In connection with the above project and following our conversation of yesterday, please find attached a copy of our amended drawing no's. dd23/1098/L1000 Rev. B and dd23/1098/L1001 Rev. B for your information.

**From:** Amanda Brown <[amanda.brown@southnorfolkandbroadland.gov.uk](mailto:amanda.brown@southnorfolkandbroadland.gov.uk)>  
**Sent:** Monday, April 8, 2024 2:09 PM  
**To:** [simon@distinctdesignsuk.com](mailto:simon@distinctdesignsuk.com)  
**Subject:** 2024/0744

SITE LAYOUT (SOUTHERN HALF)
SHEET 1 OF 2

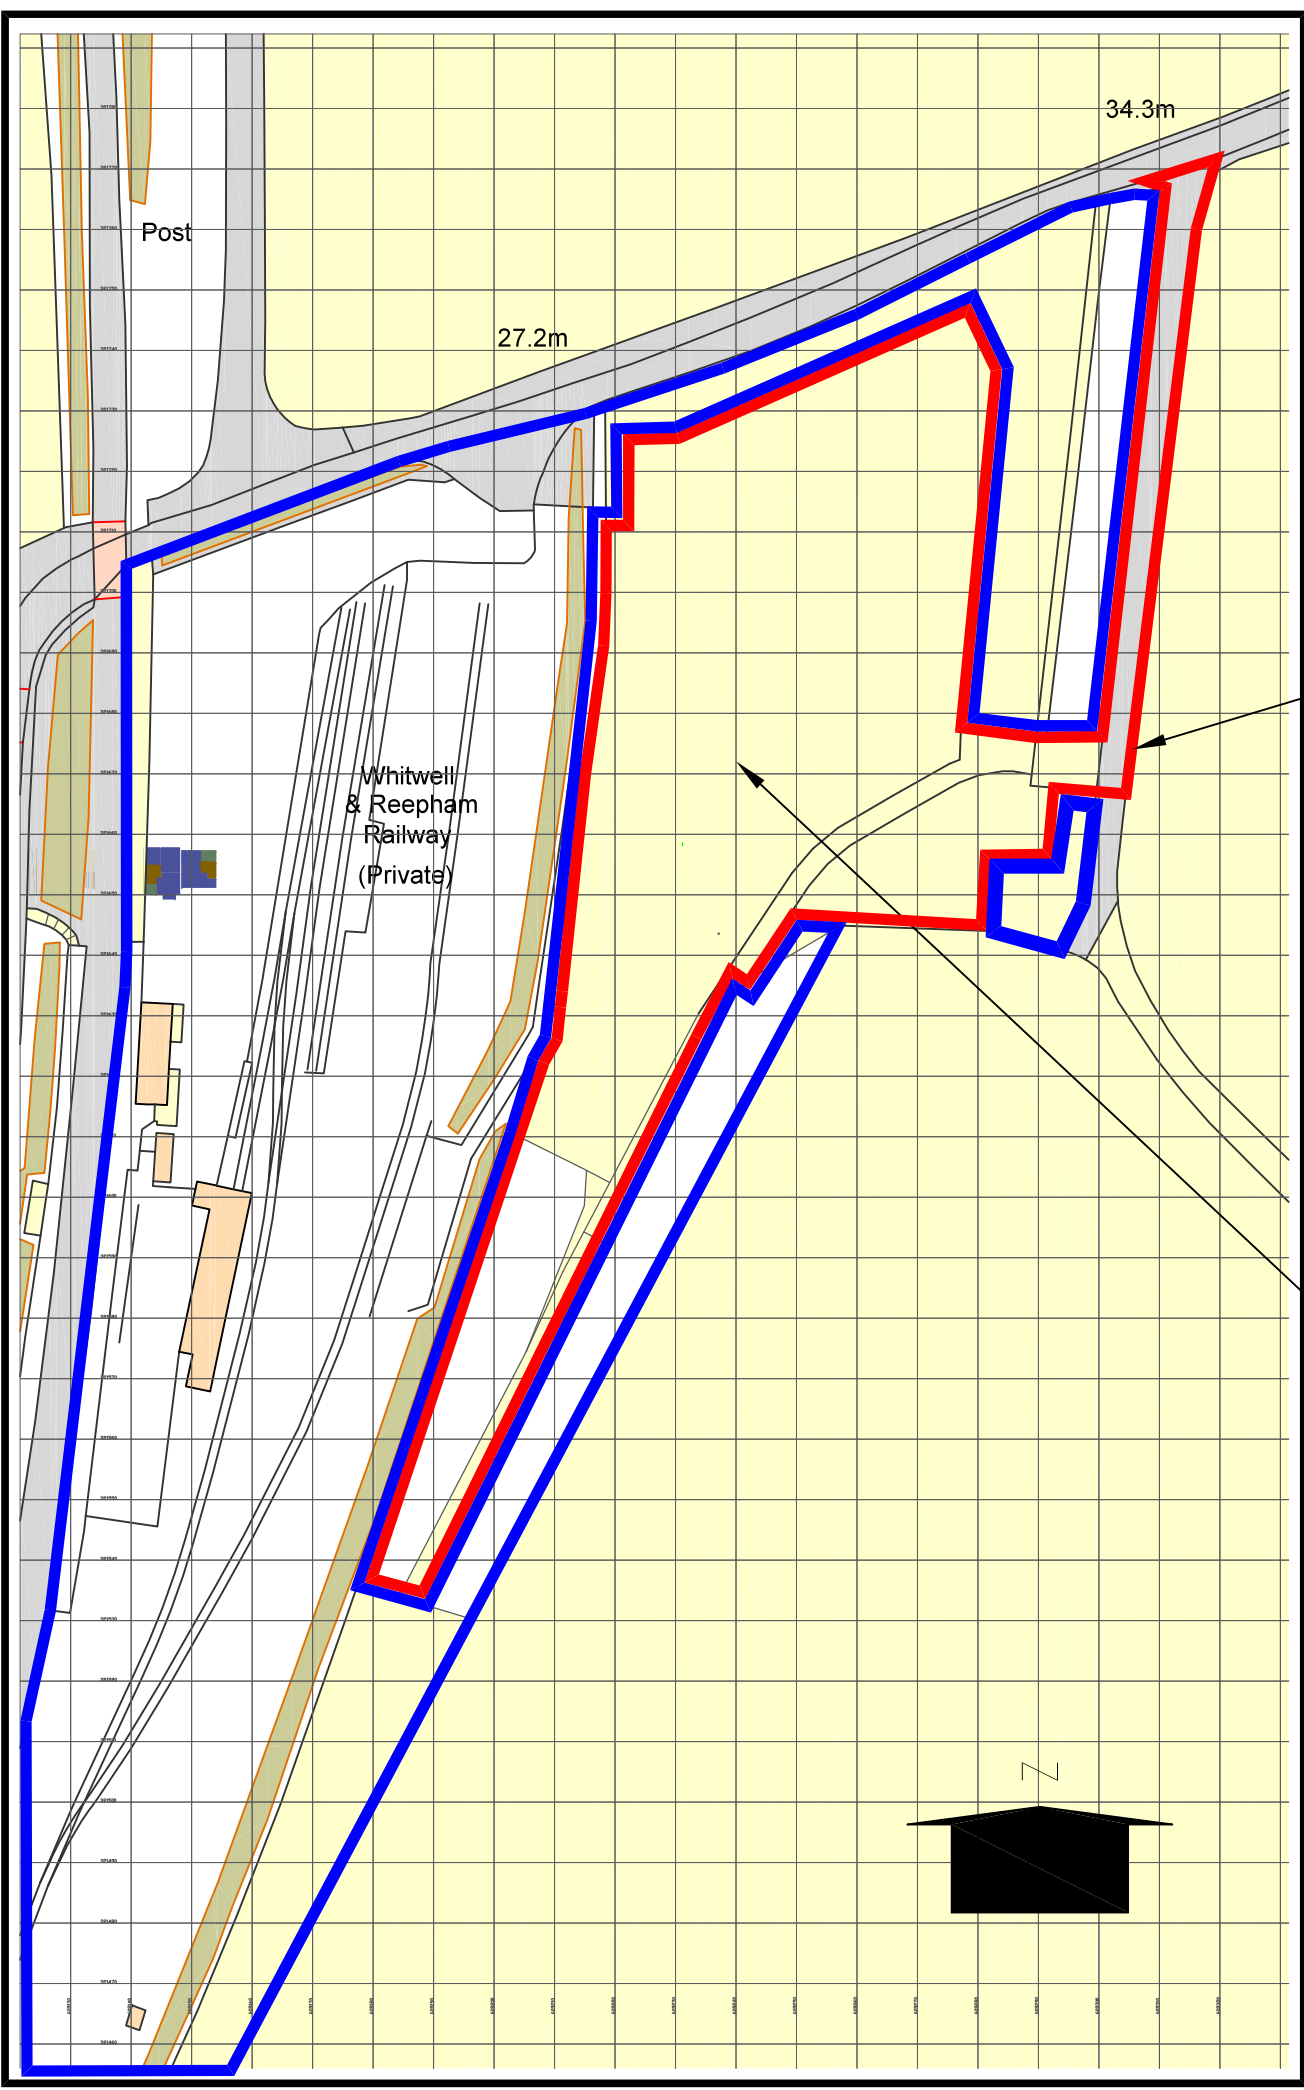
Many thanks Simon for the updated Plans I will add them to the application – can you confirm whether all 19 pitches are going to be concrete based – we need to know what the measurements are for each pitch (if they are all the same you can give me the measurement for one).

Can I clarify whether the additional 11 Touring Pitches and 8 Static Plots are going to have concrete bases – if this is the case – can you ensure that you draw these concrete bases to scale on all 19 plots.

In connection with your previous email and following discussions with our client I can confirm that the touring pitches will have a concrete base measuring 7.2m x 7.2m and the statics will have no base.
